DECISION DELEGATED TO HEAD OF PLANNING

Application No: H05-0303-22 **Applicant:** Kaplan Property Group

Proposal: Residential Development of 25 Dwellings (Phase 2) - outline approval
H05-0468-18 - with access via Phase 1.

Location: 50 Fleet Road Fleet Spalding

Drawing Title:
Phase 2 - Proposed Site Sections

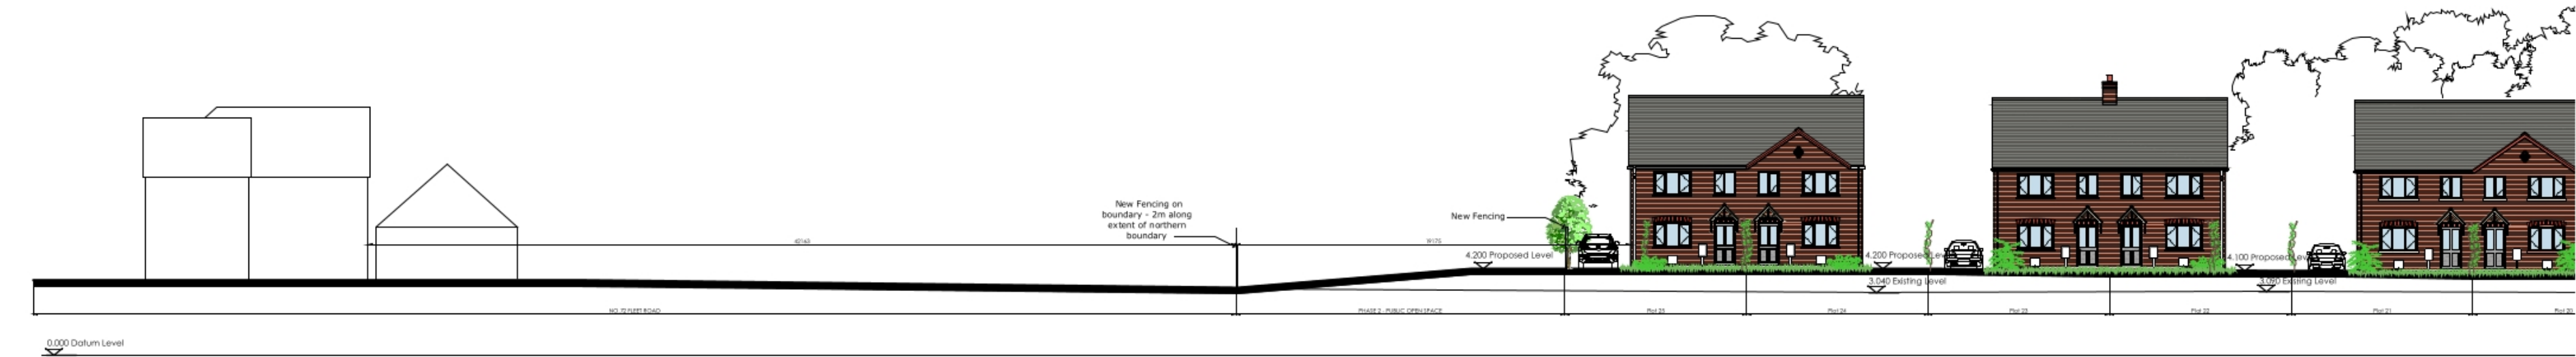
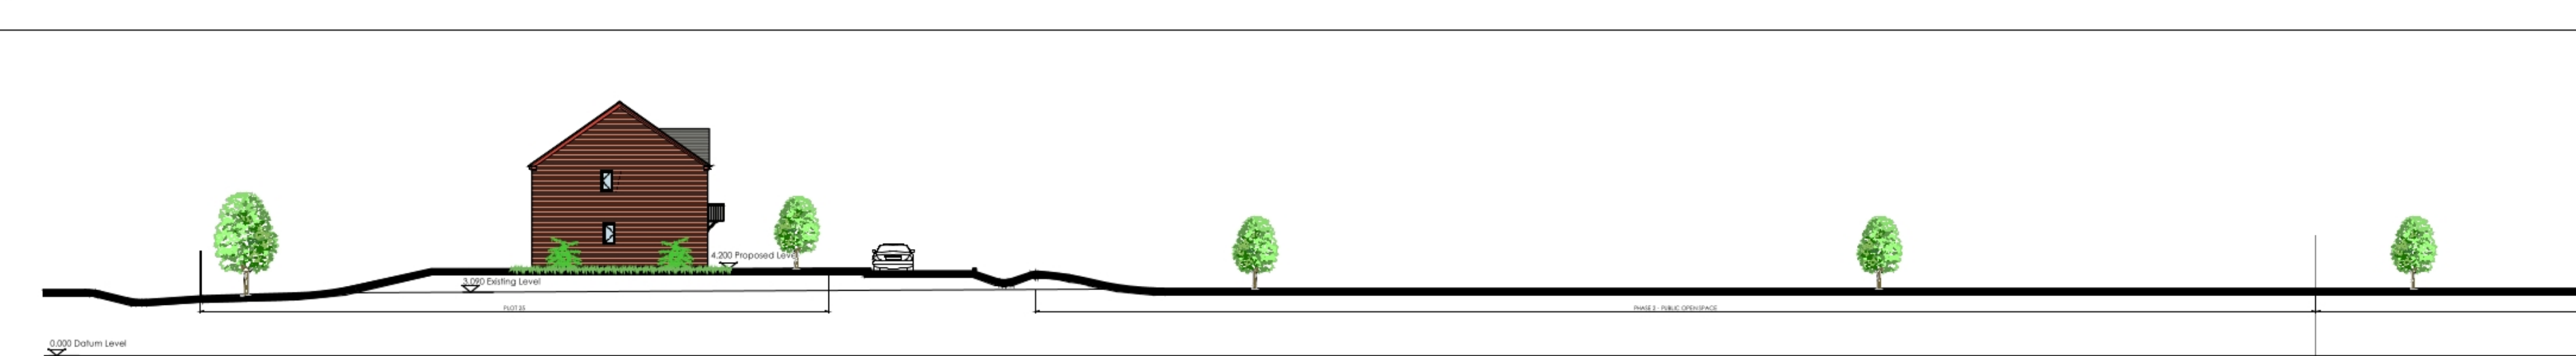
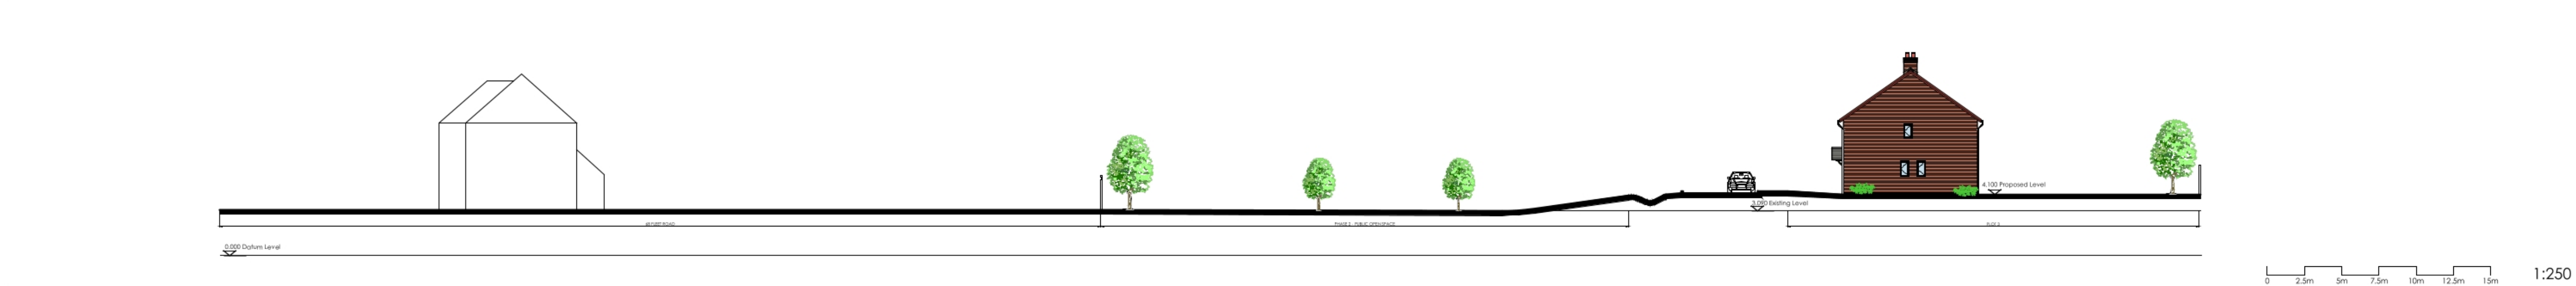
The dwellings on plots 1-4 are set well back (approx. 49m) from the northern boundary. The road level at this point would be in the region of 4-4.2m aOD and finished floor levels of plots 1-4 set between 3.9 and 4.1m aOD. The closest dwelling to the northern boundary is a 3 bed semi-detached house on plot 25 (FFL 4.20m aOD) which is some 22 metres from the boundary with a bathroom window on its northern elevation at first floor level. Two metre fencing is proposed along the northern boundary which is considered satisfactory given the separation distances involved and

the depth of neighbouring gardens. The scheme includes a filter drain along the northern boundary.

APPENDIX G – PROPOSED DRAINAGE STRATEGY & ENGINEERING LAYOUT

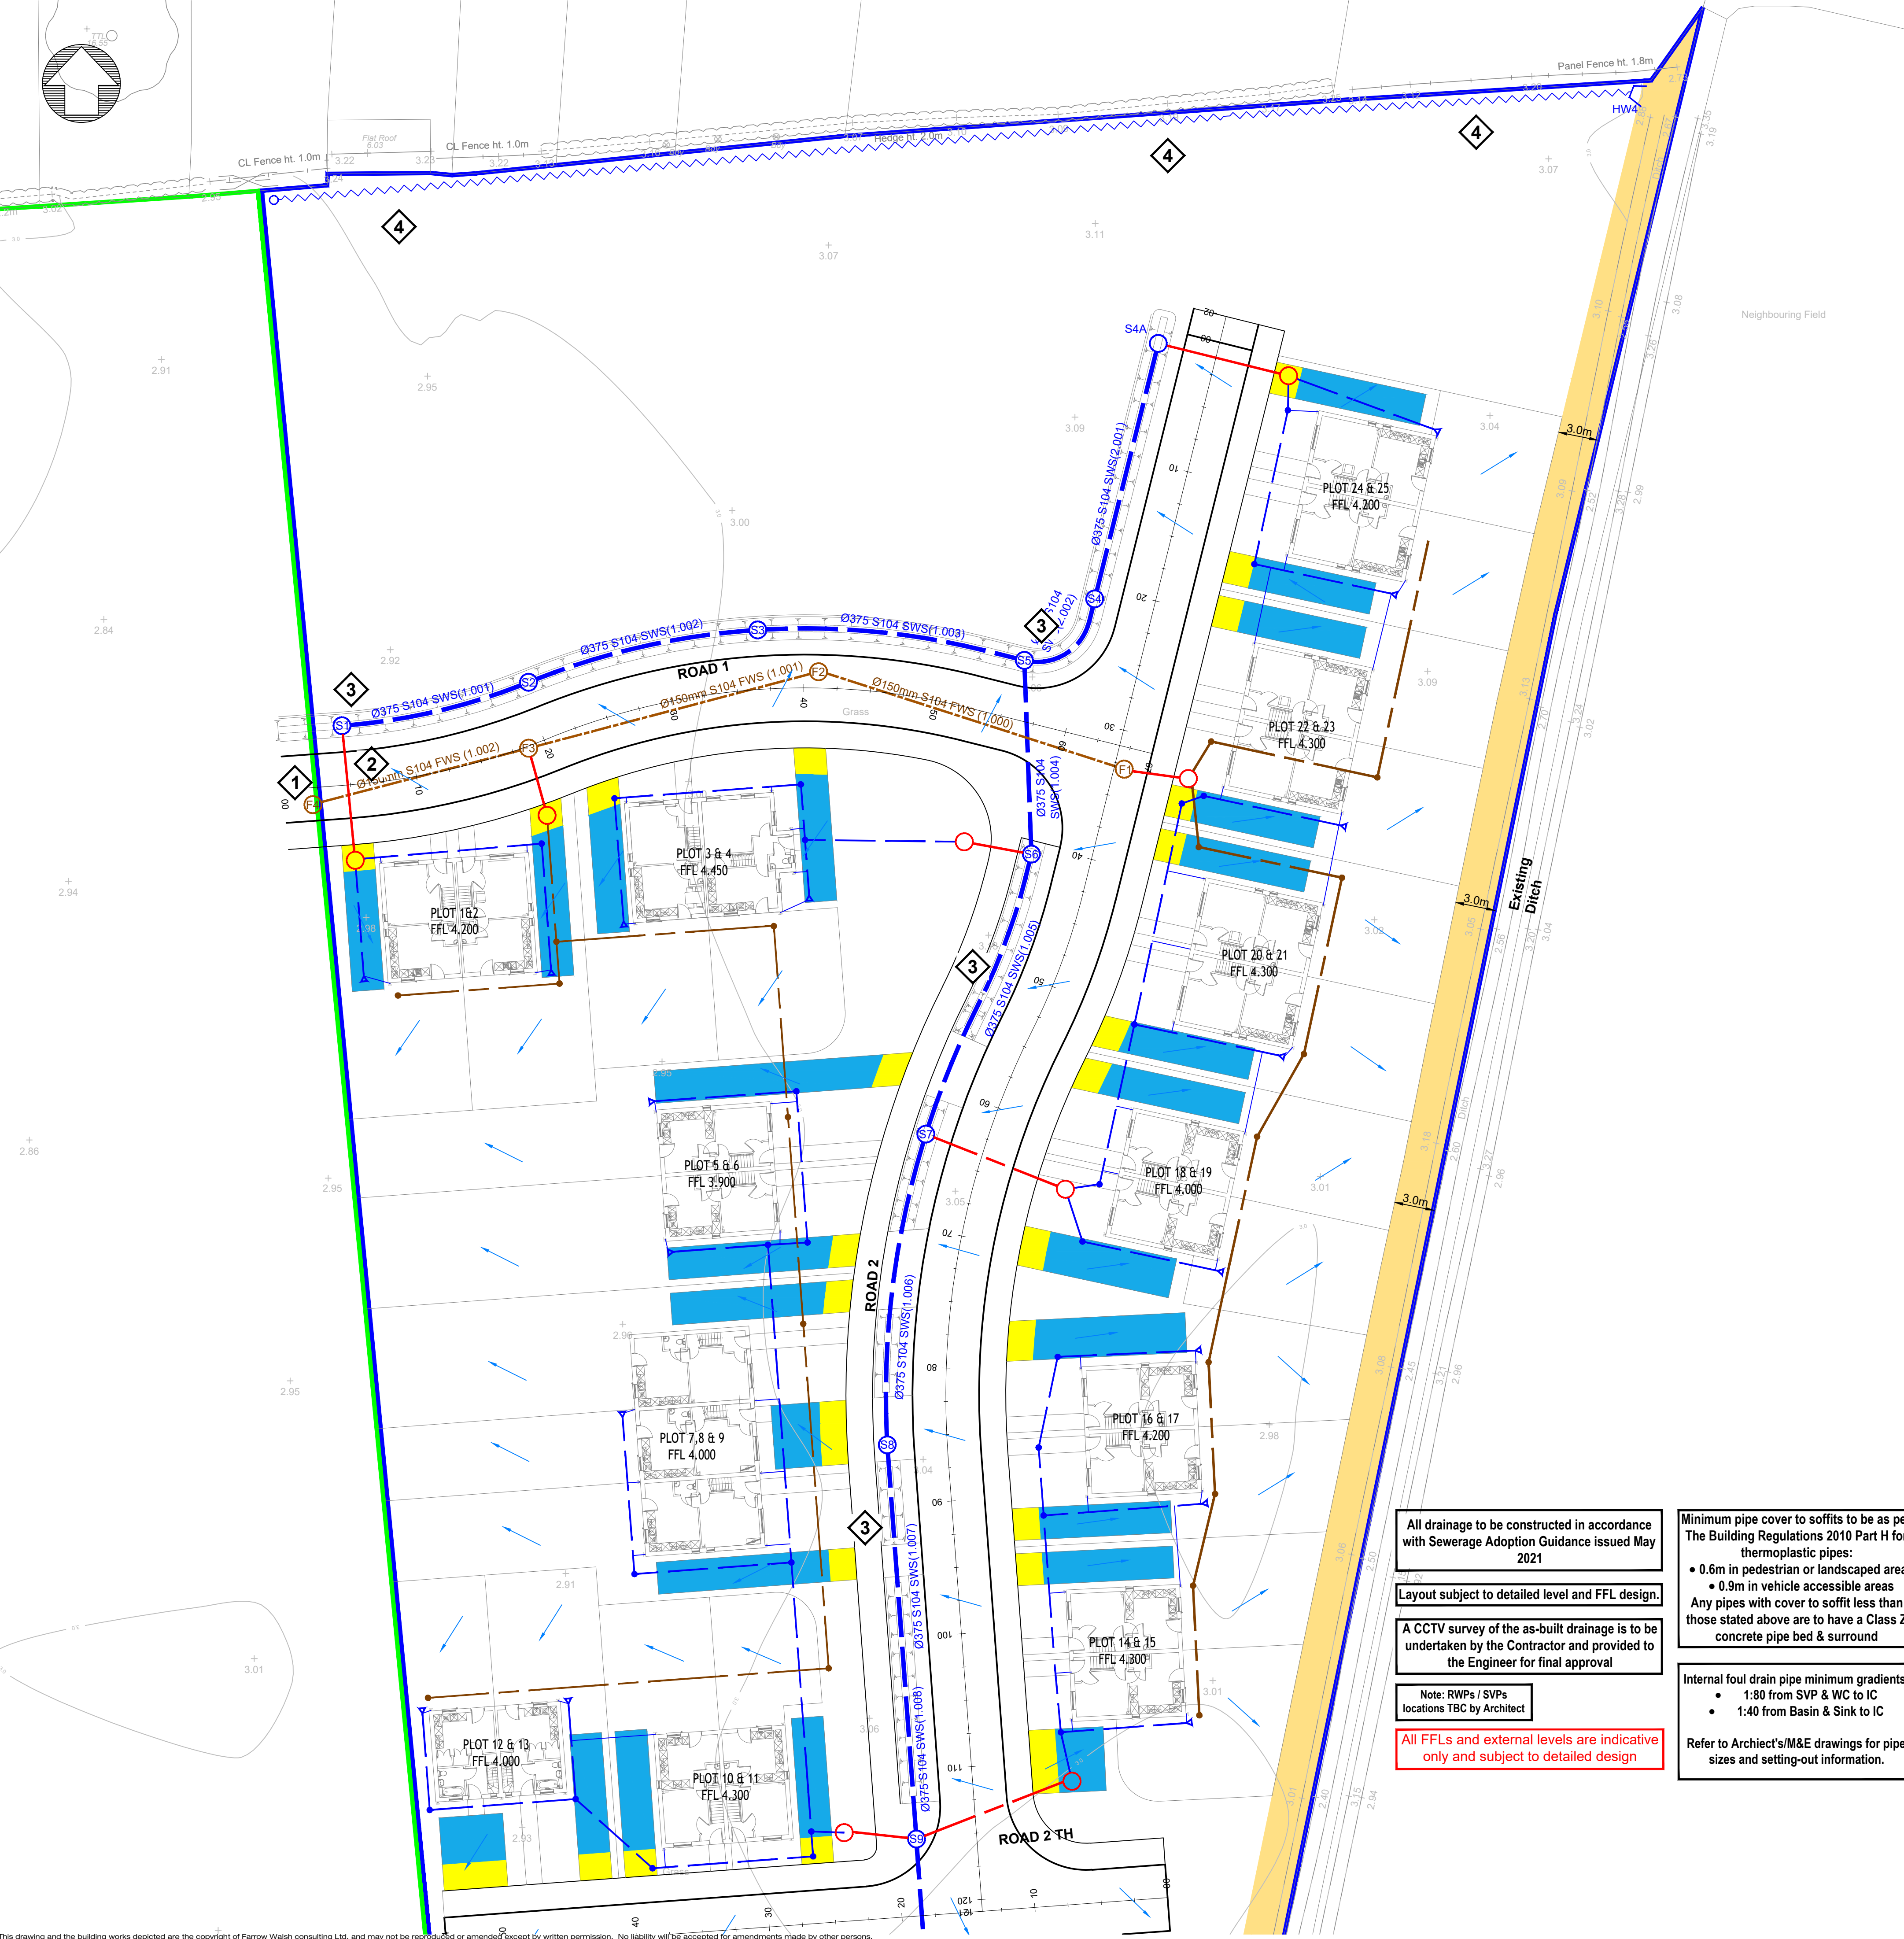
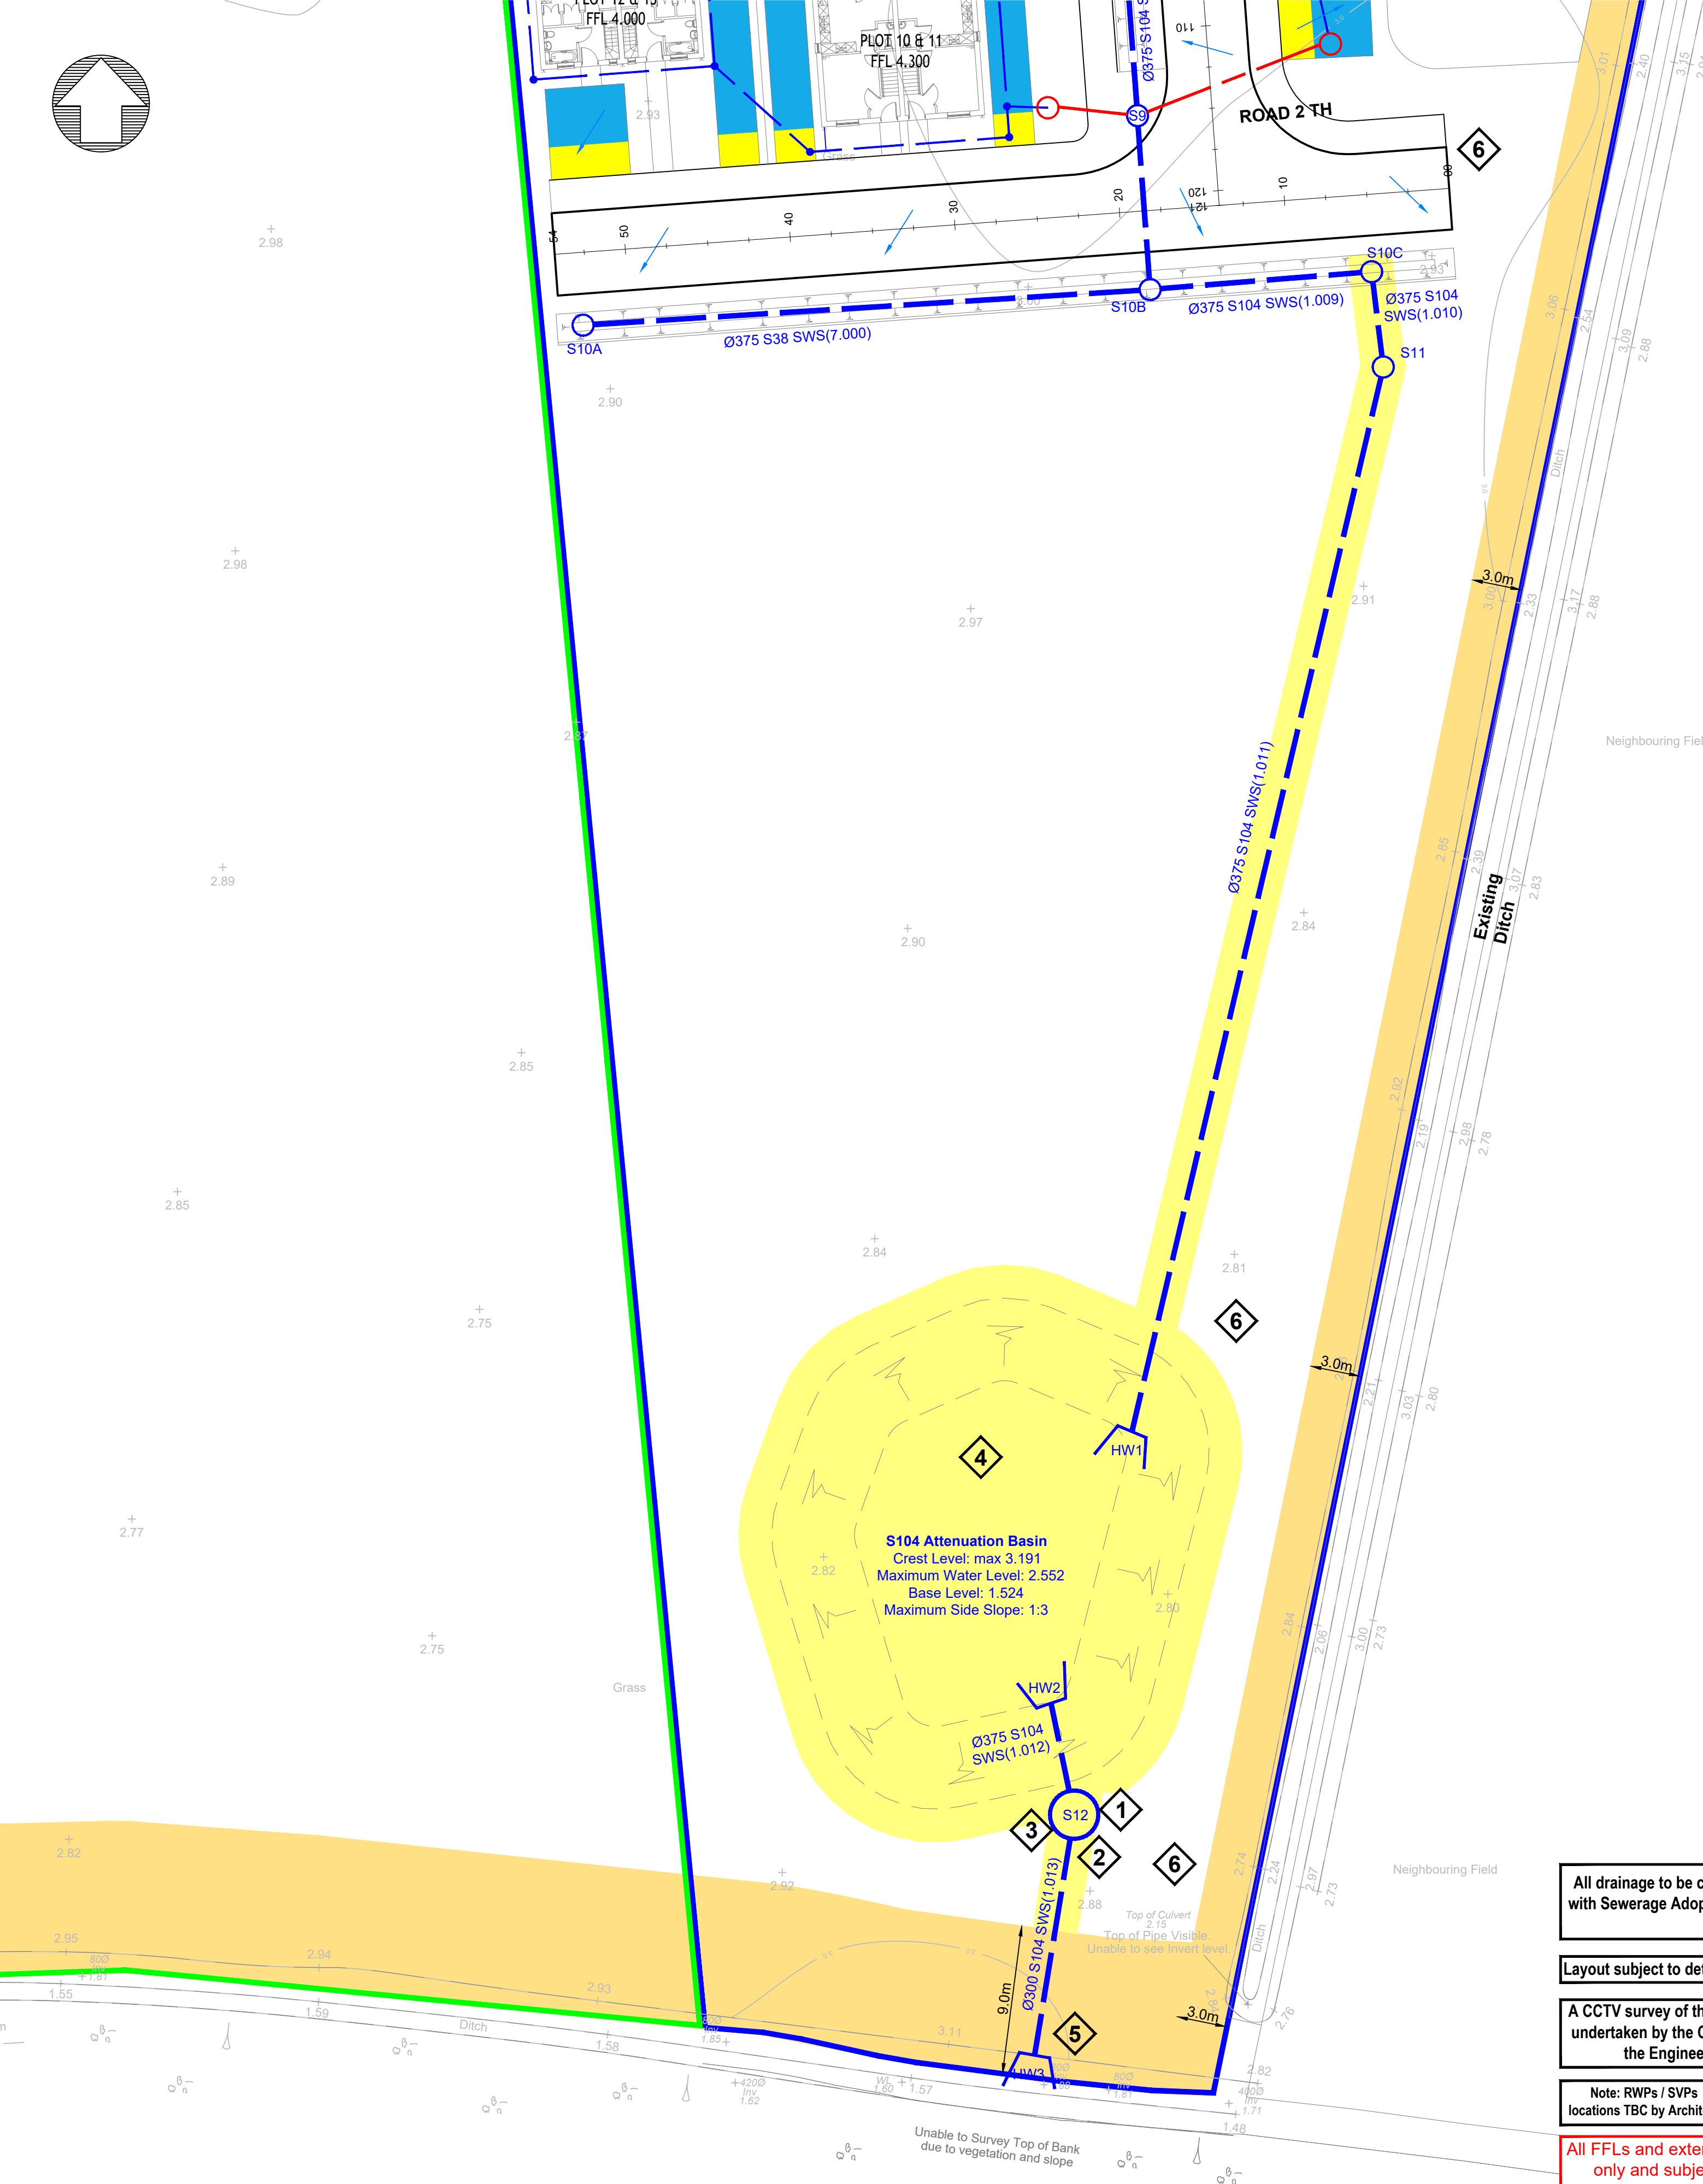
The applicant proposes to discharge surface water to the Board Maintained watercourse K04 Devils Hill (DRN201G0407) watercourse at a rate of 2 l/s. I am pleased to see that the applicant has aimed to reduce the discharge to greenfield rate. Regardless of the proposed discharge rate, this proposal will require consent under Byelaw 3, and I recommend that the applicant contacts this office to make an application for this consent at their earliest convenience.

Note that the applicant has now included a filter drain along the northern boundary of the site to prevent overland flows entering third party land. This will also require Land Drainage Consent in line with the Board's byelaws (specifically byelaw 3).

Note that the applicant intends to install the onsite drainage outfall pipe within 9 metres of the aforementioned Board Maintained watercourse. To enable this proposal, consent would be required under Byelaw 10.

The Board strongly recommends that Land Drainage Consent is sought from the Board prior to determination of this planning application.
